| <b>REQUEST</b>                   | Current Zoning: B-1(CD), neighborhood business, conditional<br>Proposed Zoning: B-2(CD), general business, conditional   |
| <b>LOCATION</b>                  | Approximately 2.09 acres located on the northeast corner of University City Boulevard and Sams Lane.   |
| <b>SUMMARY OF PETITION</b>       | This petition proposes to allow the construction of a building consisting of a chain pulled car wash and convenience store, with gross floor area not to exceed 8,000 square feet. |

01 SITE PLAN

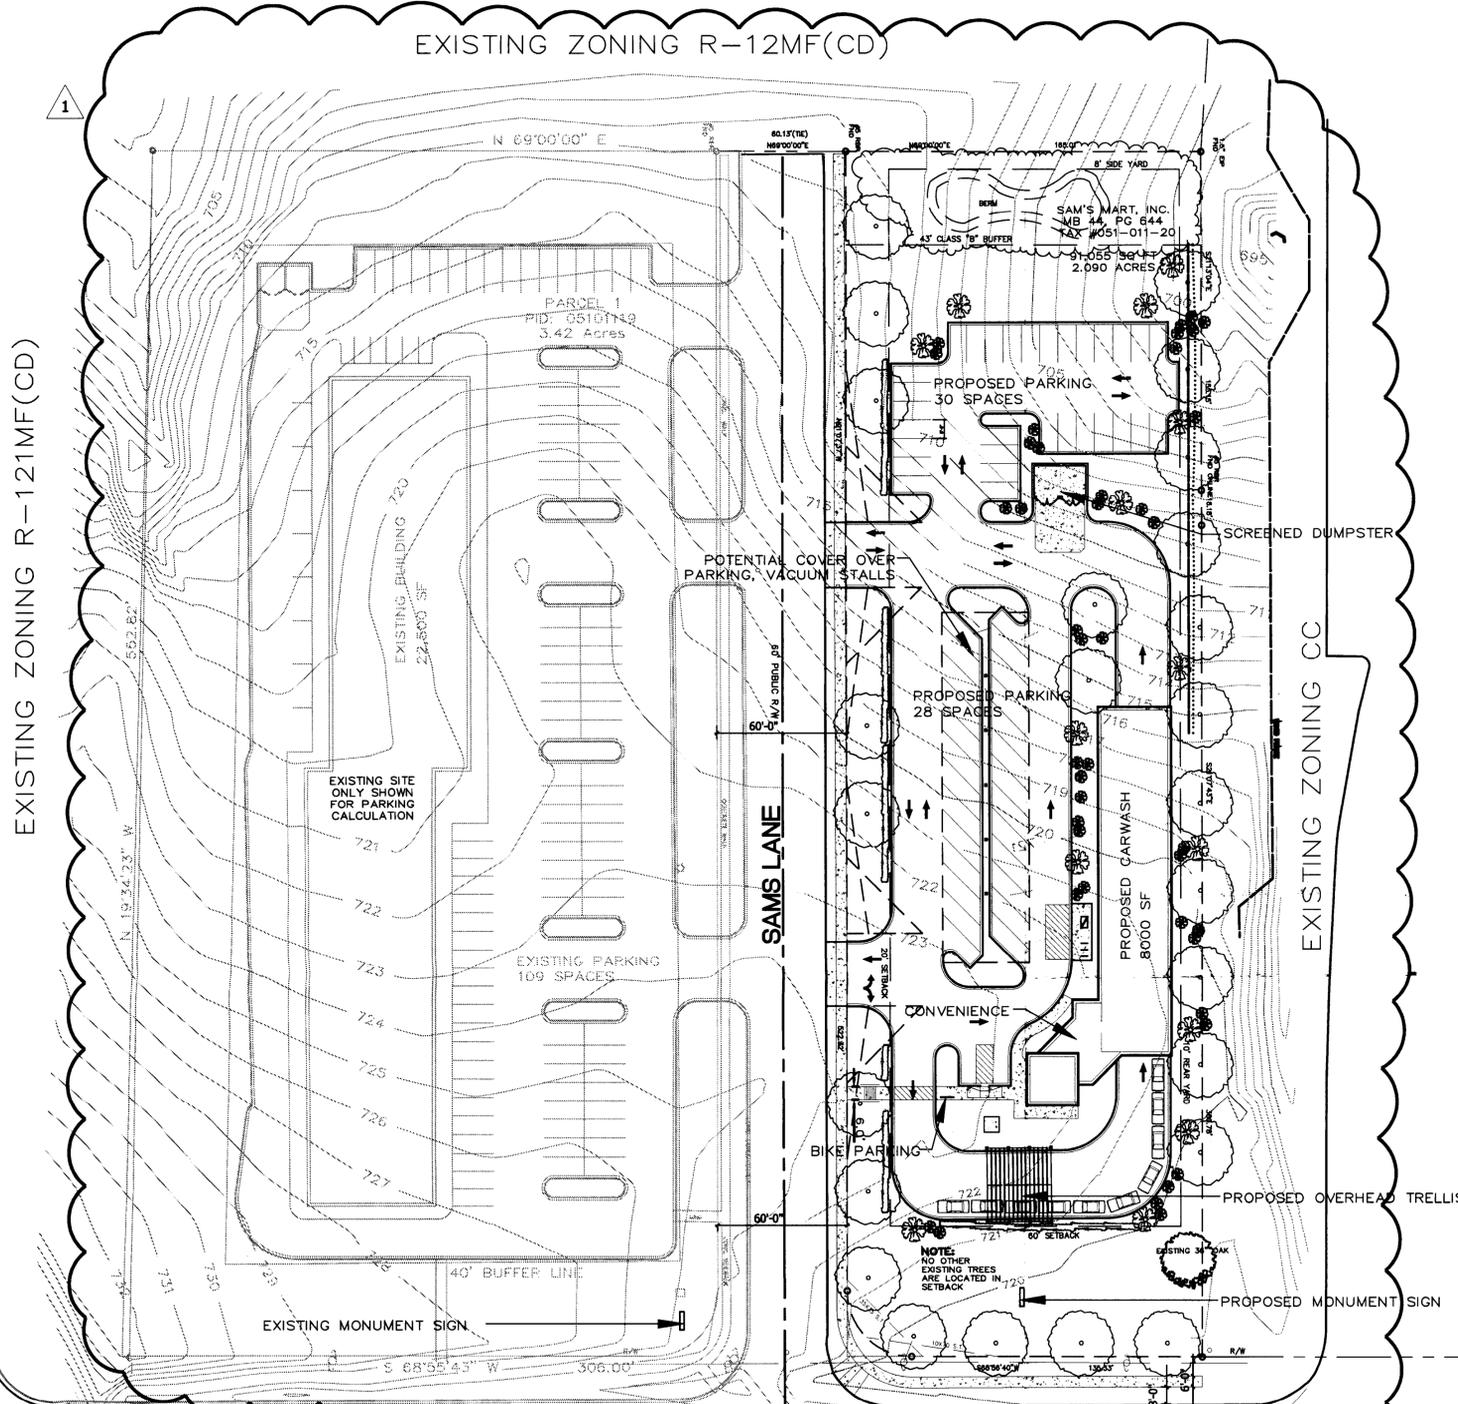
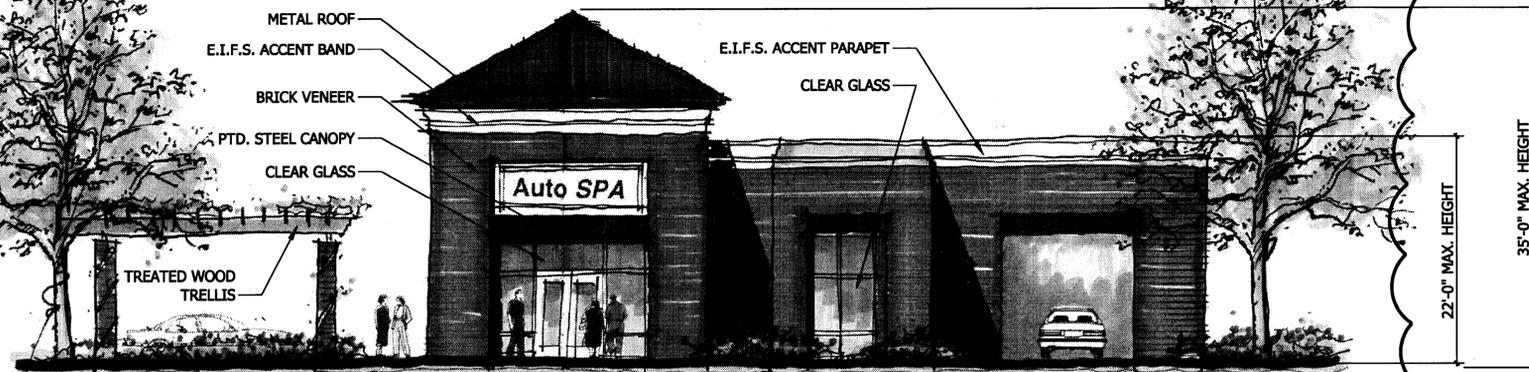
- **Vehicle Trip Generation:**  
Current Zoning: 2,200 trips per day.  
Proposed Zoning: 3,500 trips per day.
- **CDOT:** CDOT has submitted the following comments that are critical to support of this rezoning petition:
  - Two-way drive aisles are not permitted with angled parking spaces. The drive aisle must be changed to one-way operation or the parking stalls must be 90 degrees.

The parking area circulation for the proposed car wash as shown on the site plan cannot be supported without the deletion of the first driveway.  
The width of the street (Sams Lane), planting strip, sidewalk, and right-of-way needs to be shown on the site plan. If the sidewalk falls outside of the right-of-way, a sidewalk easement will need to be provided and shown on the site plan to include that portion of the sidewalk and an additional two feet for maintenance purpose.  
The developer needs to construct eight-foot planting strips and five-foot sidewalks along Sams Lane.  
The configuration of the drive aisles to the northern-most parking areas needs to be better aligned for through movement.

**Connectivity:** Primary access is proposed via access from University City Boulevard onto Sams Lane. CDOT does not support the first driveway due to concerns with the parking area circulation for the proposed carwash.

1. Amend the labeled *Class "B" Buffer* identified along the north property line to state *Class "B" Buffer with Berm*.
2. Confirm that the parking provided for the existing one-story office/retail building meets the parking requirement.

3. Amend the site plan to correctly identify side and rear yards, including required widths. The labeled rear yard along the east property line is actually a side yard, and the labeled side yard along the north property line is actually a rear yard.

4. Label on the site plan the required sidewalks and planting strips along Sams Lane and University City Boulevard.
5. Add a note to the site plan agreeing to provide a Solid Waste Management Plan prior to initiating land clearing, demolition and/or construction activities.

6. Address the request from CATS for a waiting/bench pad.
7. Address all CDOT comments noted above.
8. Specify the maximum building height.
9. Amend Note 4 under Lighting to state that lighting will be shielded with full cut-off fixtures.
